Please ask for: Ms Iqraa Malik
Email: iqraa.malik@terraquest.co.uk
Telephone: 0121 234 1390
Our Ref: AW/299/24/HH
Your Ref:
Date: 12th December 2024

Application for Planning Permission for Works or Extension to a Dwelling

Development: Demolition of the existing porch and detached garage. New rear/side flat roof extension, front porch extension. Conversion of the first floor roof space with new front and rear dormers.
Location: 8 Cherry Close Aldwick PO21 3BA

EXISTING GROUND FLOOR PLAN

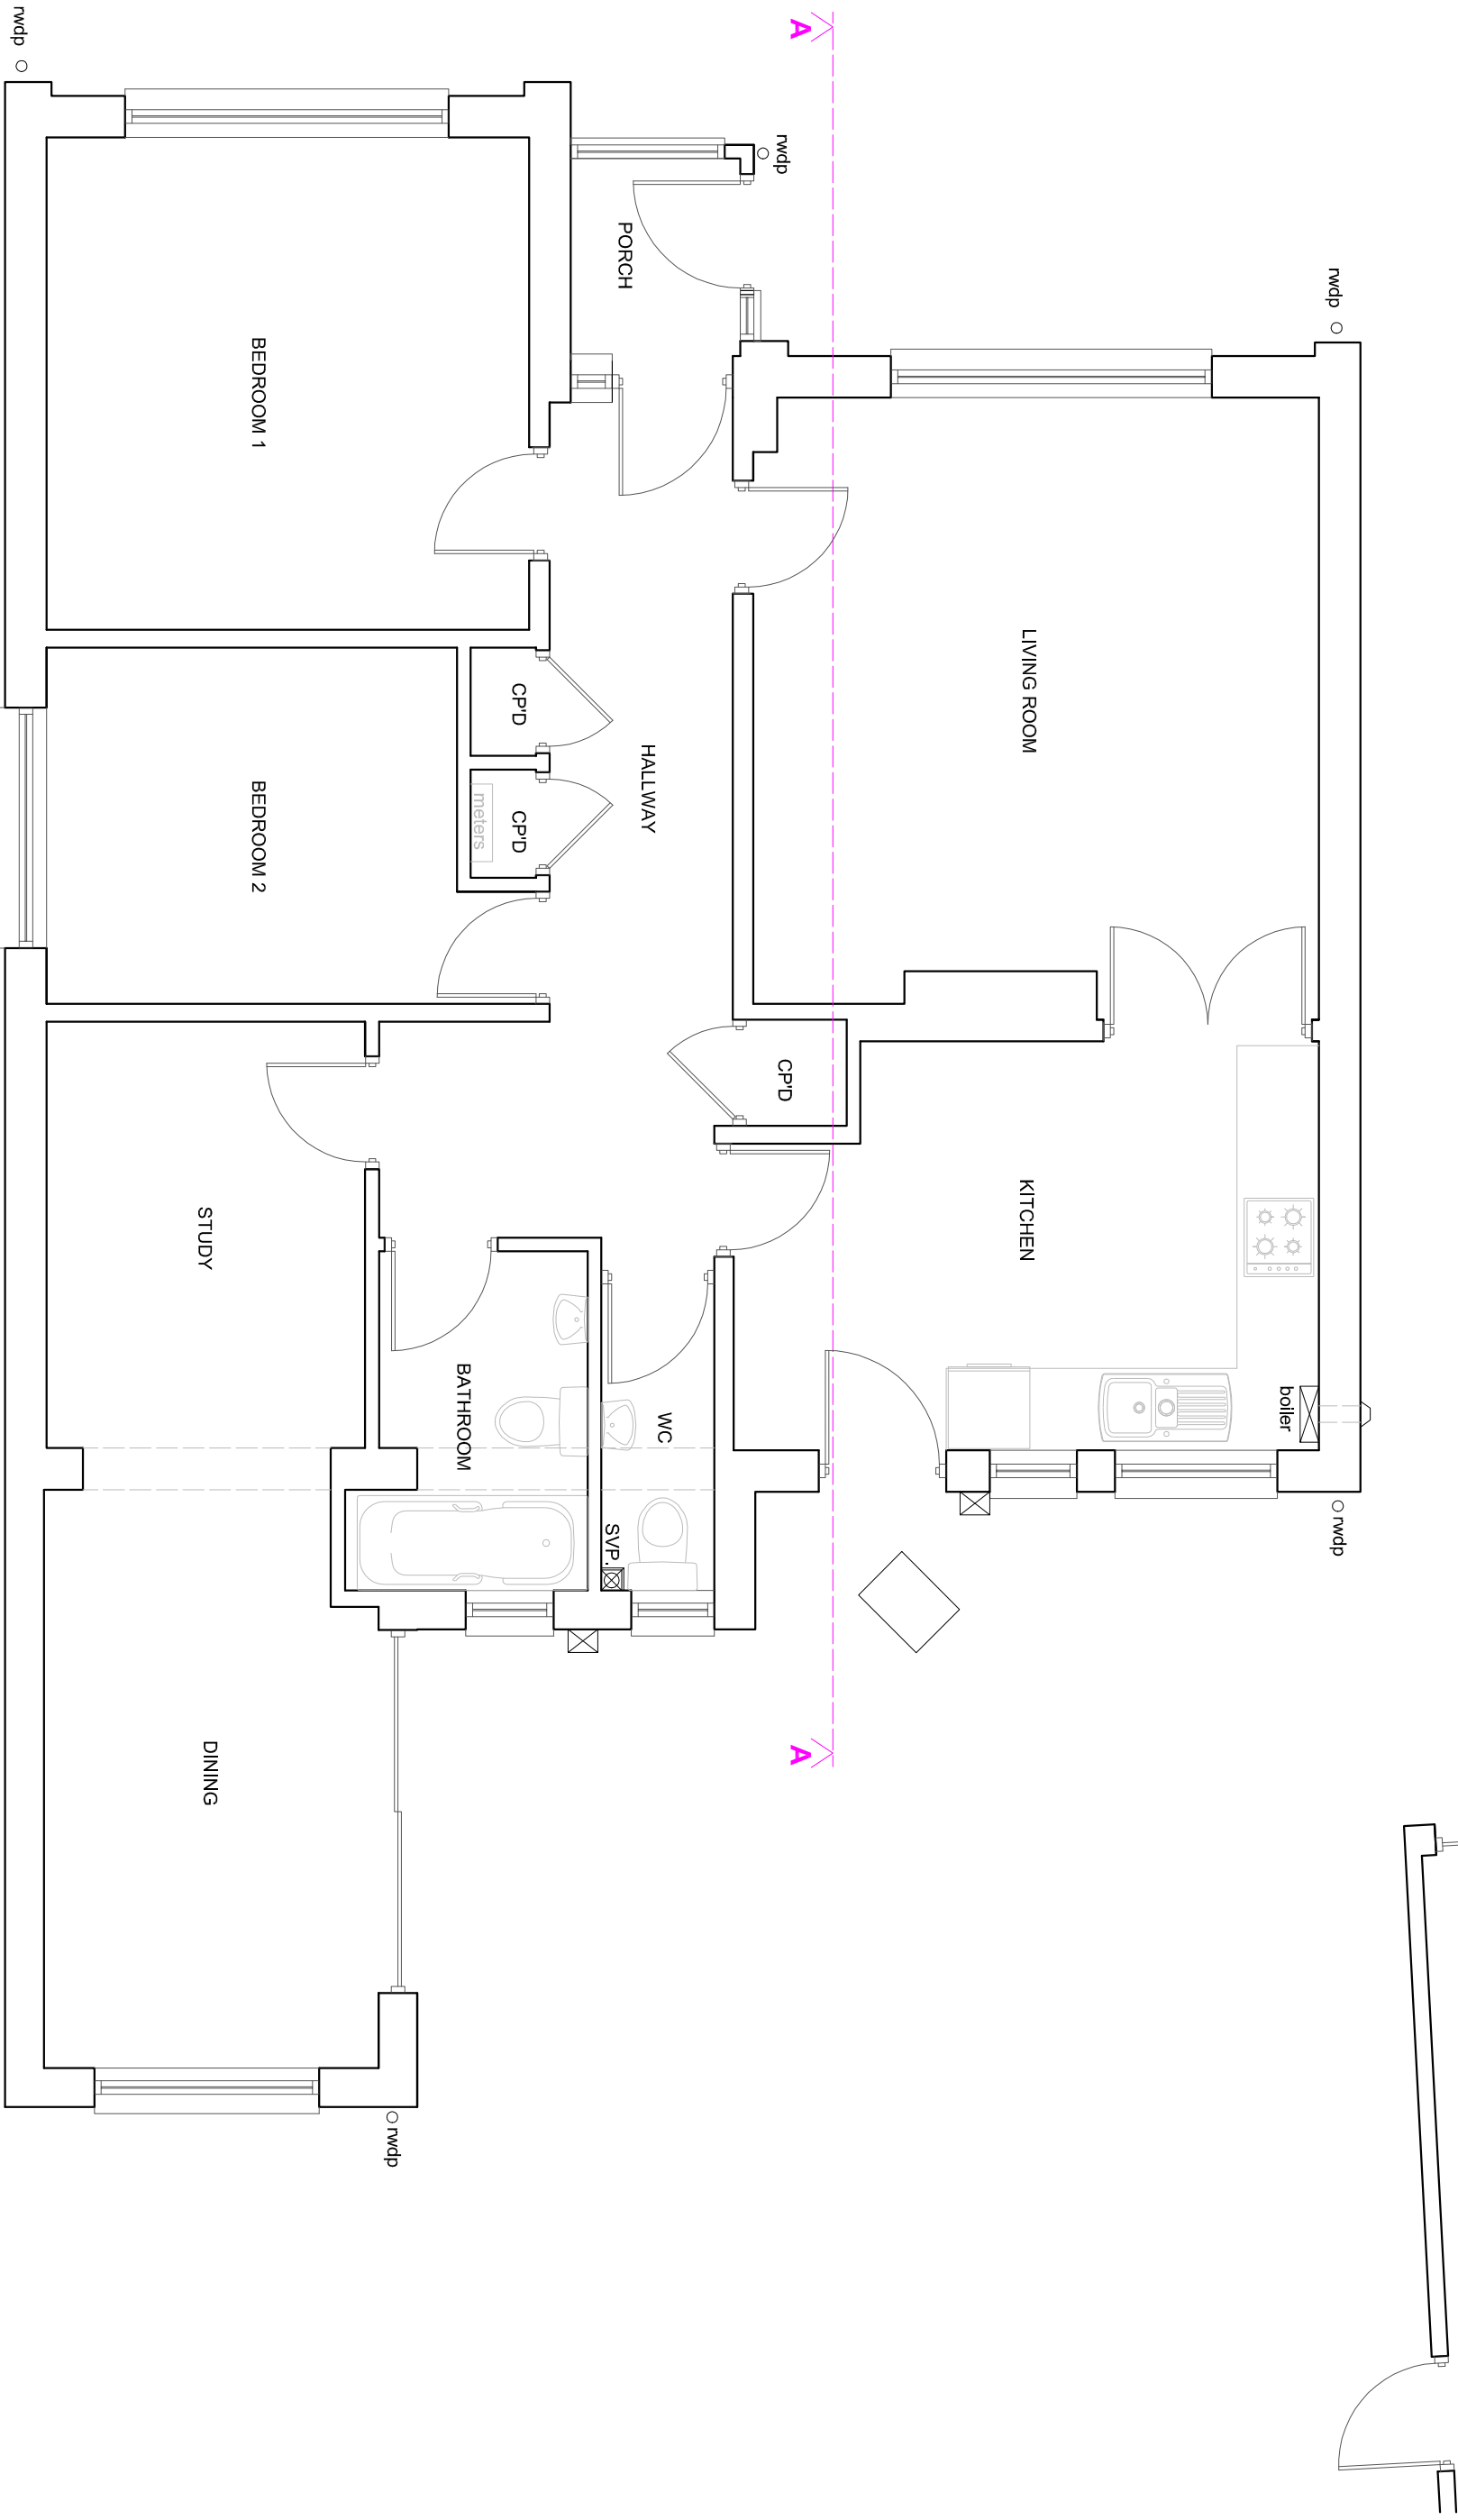
The existing ground floor plan is inconsistent with the existing side and rear elevation, please review and amend.
